Submission: Objection to SSD-82599709

Concerns: Solar Amenity; Design Quality

This submission objects to SSD-82599709 due to the poor level of solar amenity that will be offered to future residents. The proposal would deprive future residents of direct sunlight beyond what constitutes acceptable merit-based practice under the NSW Apartment Design Guide (ADG).

## South Facing Apartments

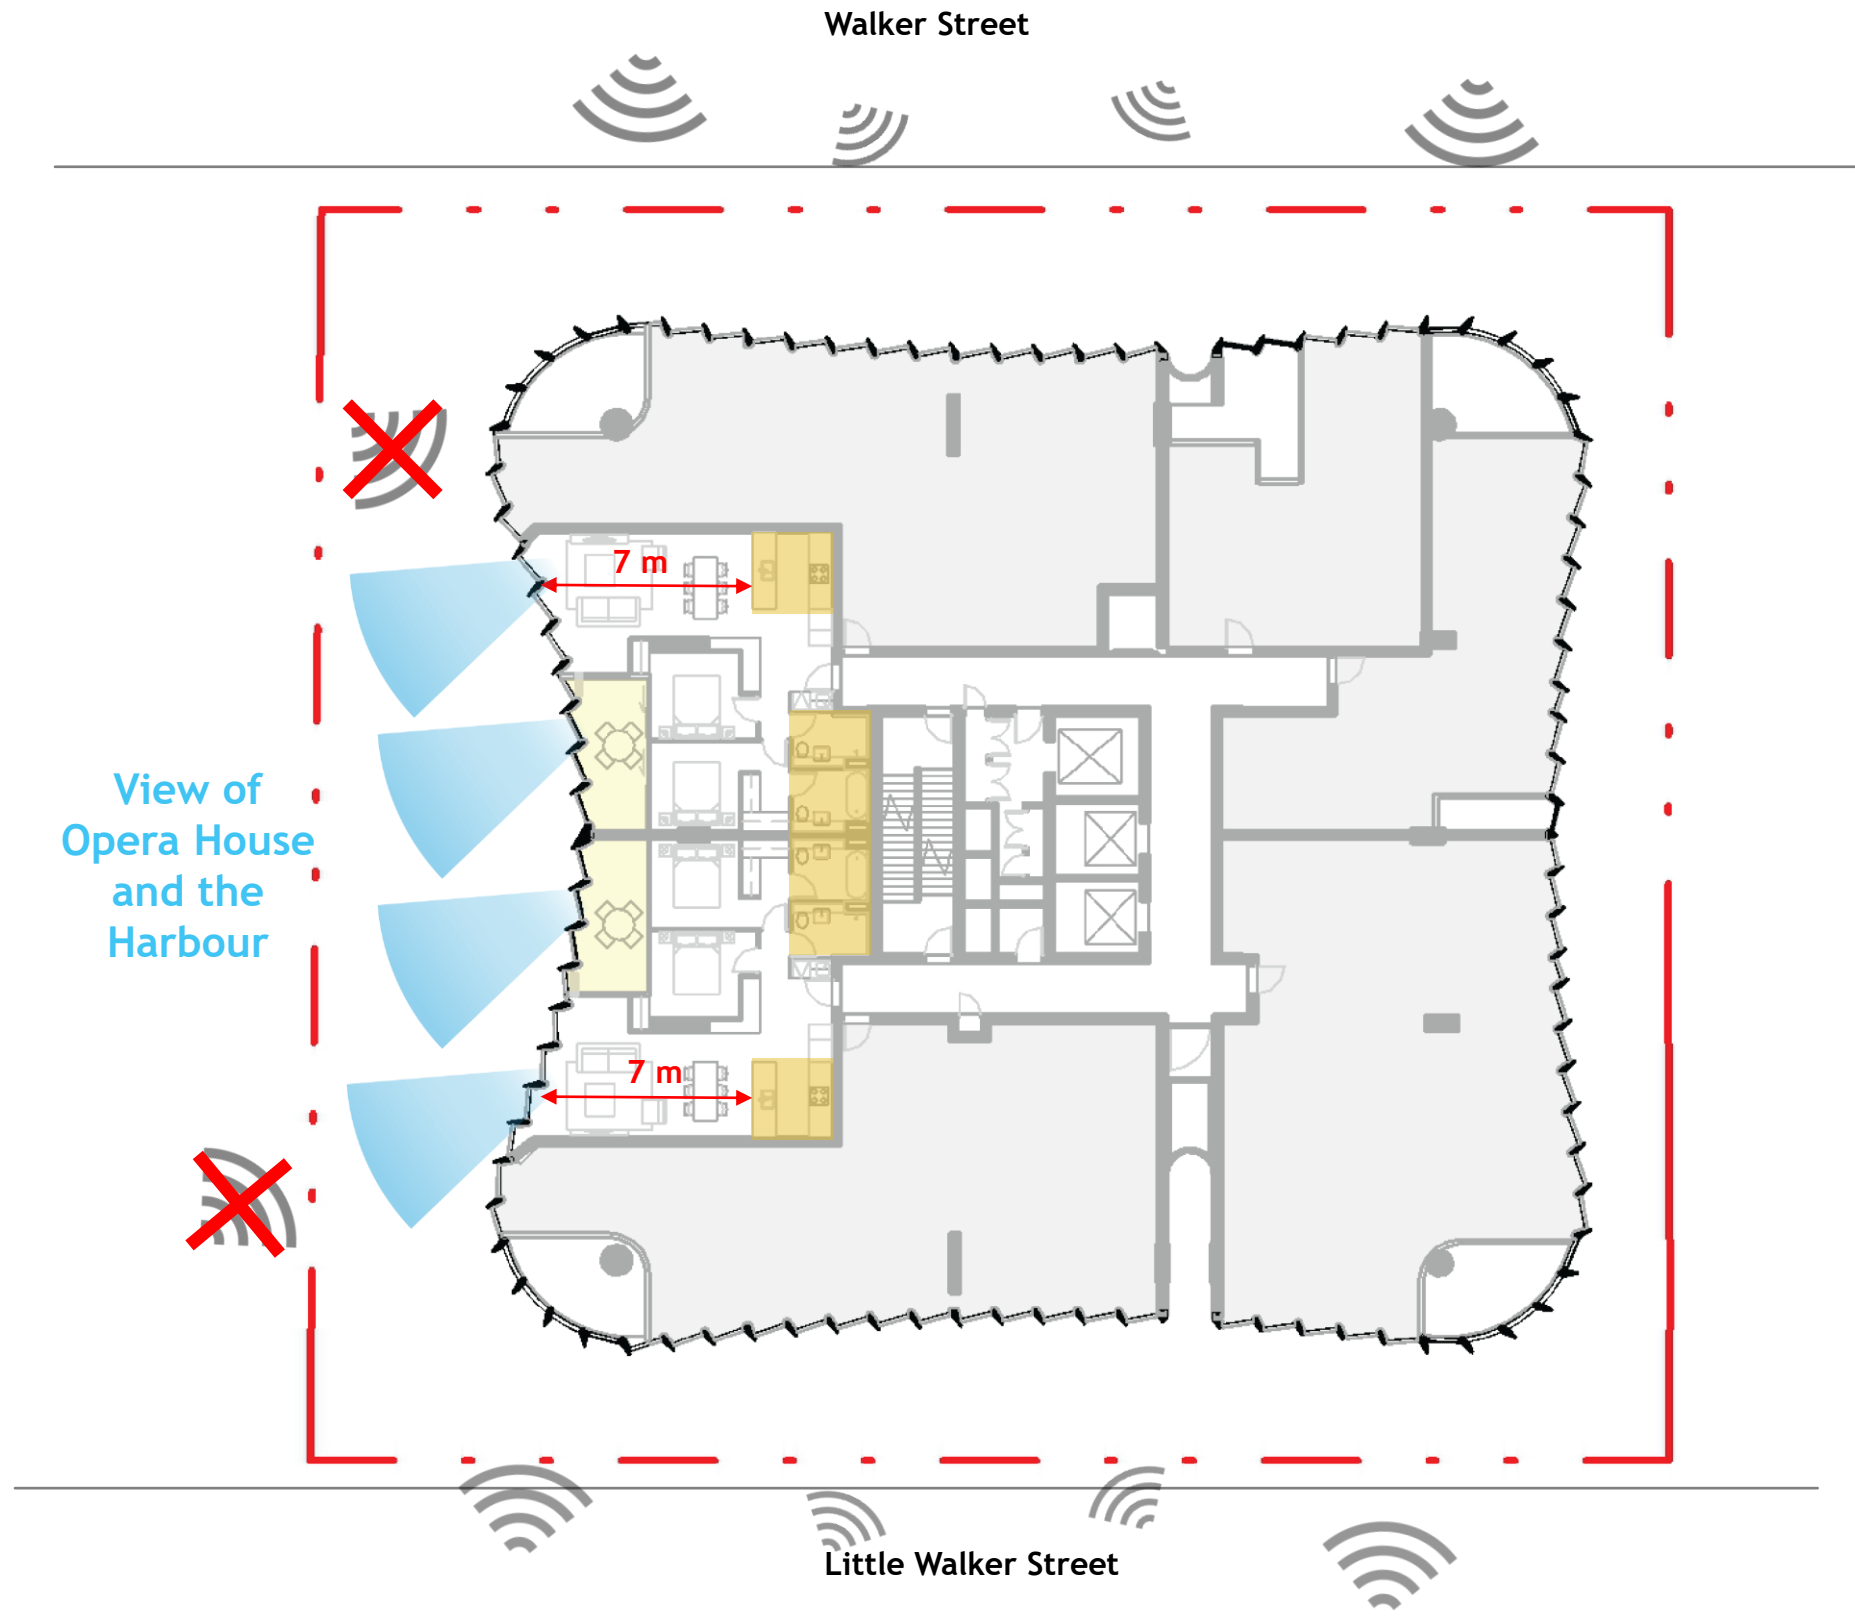
Section 4A of the ADG requires that no more than 15% of apartments receive no direct sunlight between 9:00 am and 3:00 pm on 21 June. 25% of the proposed apartments will receive no sunlight on 21 June.

By contrast, SSD-82599709—which is not eligible for the same level of flexibility—proposes south-facing apartments, directly contributing to the non-compliance where 25% of units receive no sunlight on 21 June.

- Reduce the number of south-facing apartments by substituting these with additional hotel rooms, which are not subject to ADG solar provisions.
- Refine tower massing to remove south-facing apartments without reallocating the use of floor space to expand the hotel. This could provide a more slender tower, which may create additional space for:
 - Modulation or steps at high-rise levels.
 - Genuine outdoor communal open space for residents above the podium, which the current proposal lacks.
